# CITY OF ALBUQUERQUE

August 19, 2016

**Re: Freddy's  
131 Coors Blvd NW  
Requested for 60-Day Permanent C. O. - Accepted  
Engineers Stamp Date 7/7/15 (K10D001B)**

DRAWN BY
DY
DATE
7/07/15
2015036-GRE
SHEET #
C1
JOB #
2015036

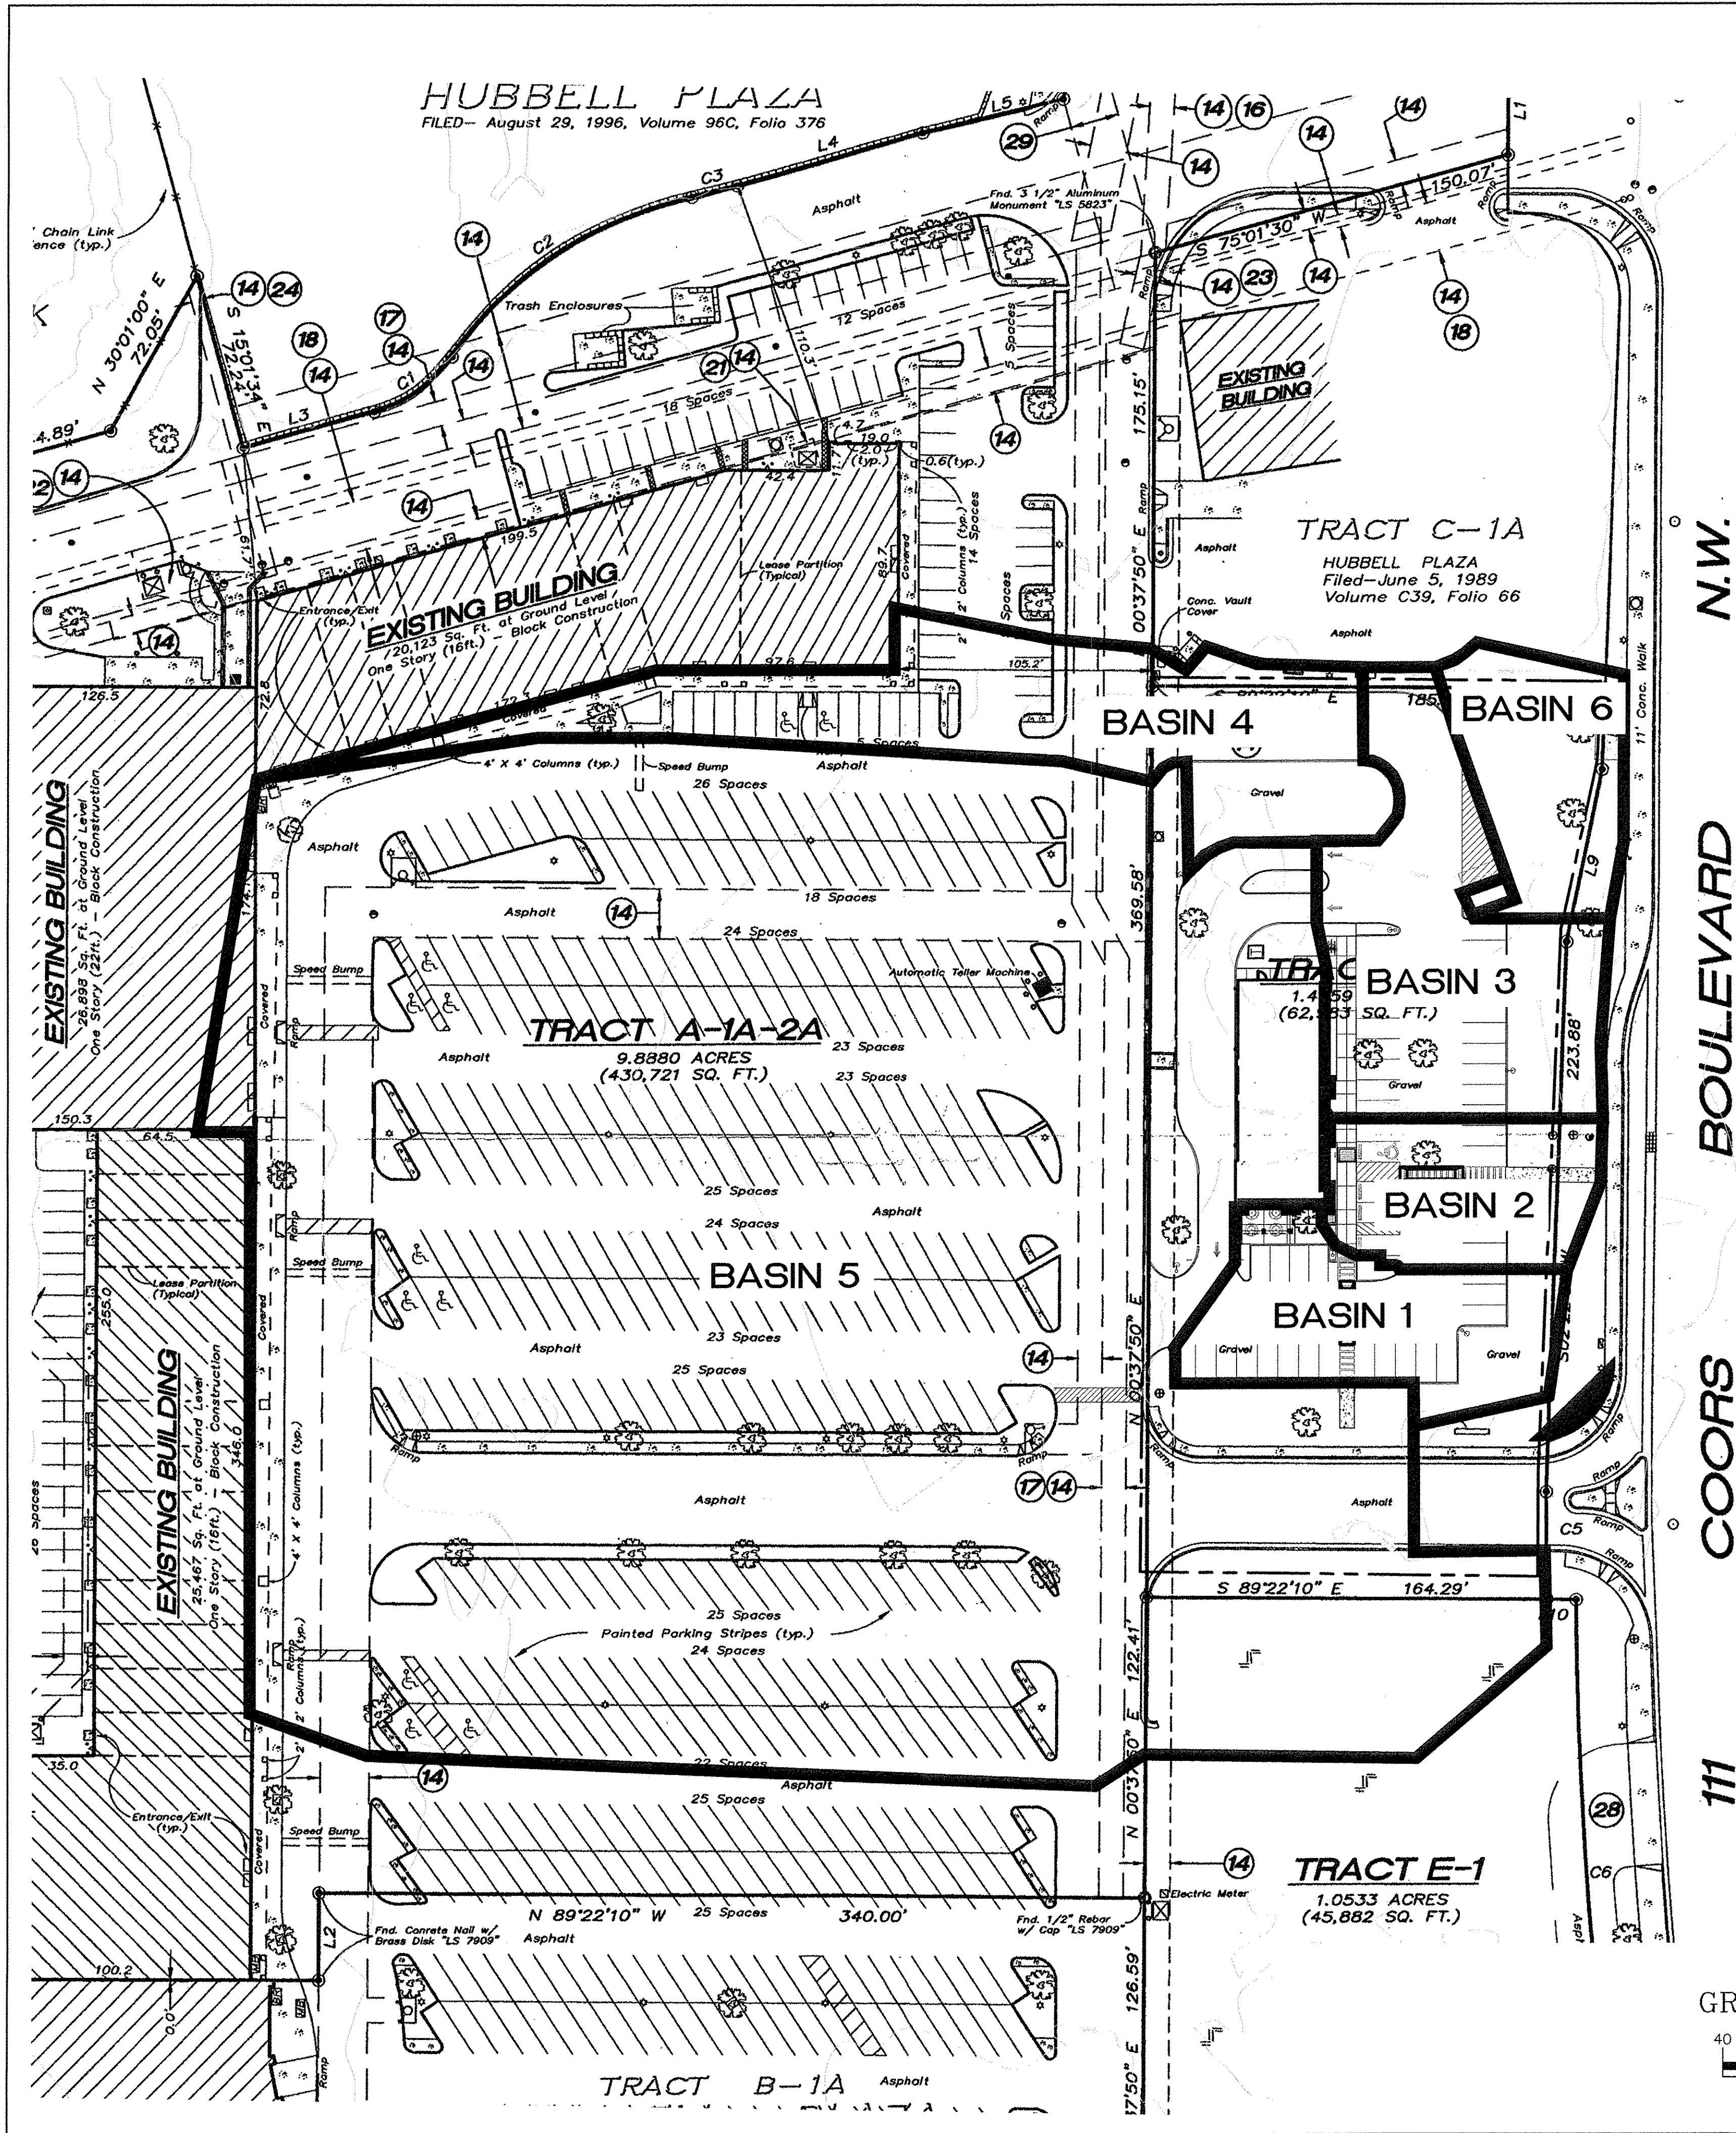
- The Emergency Spillway appears to flow back into the pond. Per the drawings the flow was towards the NE corner of the spillway. Should the ponds every completely fill up the water may back flow into the site.
